Erection of 2 no. dwellings
Land adjacent 1- Holkham Cottages Burndell Road Yapton

Thank you for your internet representation made on 27th July 2018 which has been recorded as '**an objection**' with the comments as follows:

DRAWING TITLE
Proposed Site Plan
Location and Block Plans

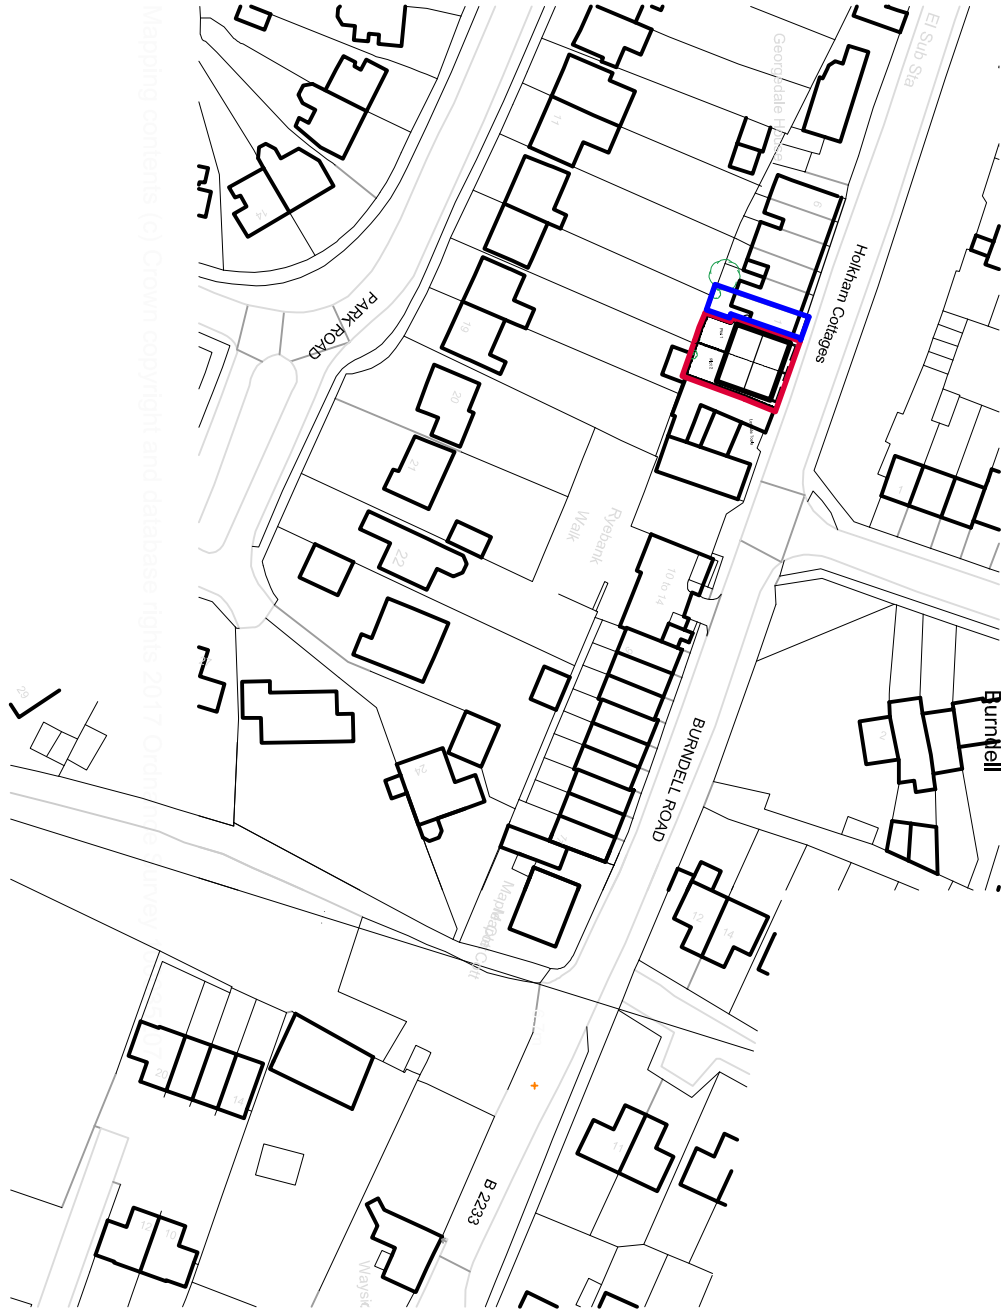
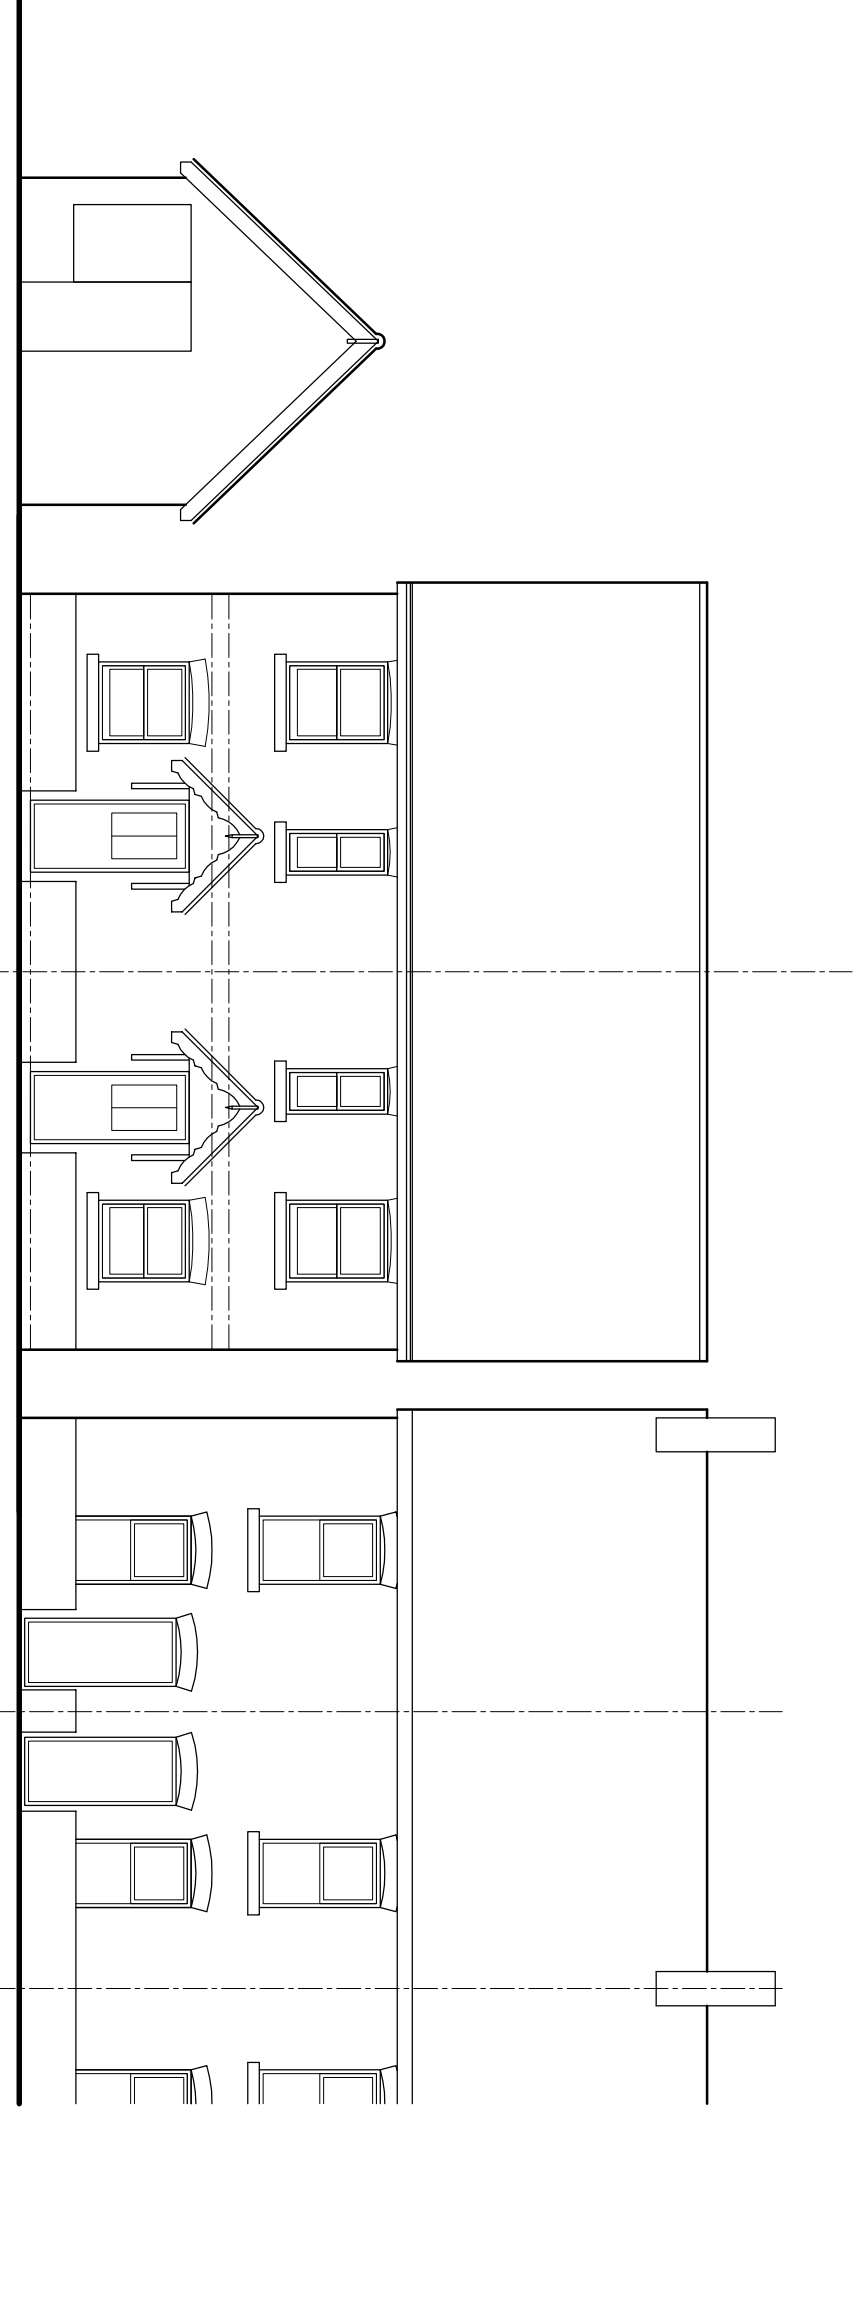
The plans outline there is a distance of 5.5m from the rear of the development to the existing boundary to the property in Park Drive. Having observed the site there is no room for a soakaway as outlined in the plans. I understand a Soakaway should not be built within 5m of the proposed development and ideally should be remote from boundaries in case the neighbour of the property in Park Drive wishes to build.

The is no provision for parking for this new development. If cars and delivery vehicles are to park outside the new properties this will cause traffic flow problems along Burndell Road and at the junction of Downview Road. This is already an issue with residents of Ryebank walk parking their vans and lorries on the Downview Estate because there is inadequate parking for larger vehicles. Therefore this development will have a negative impact on the residents in Downview Road.
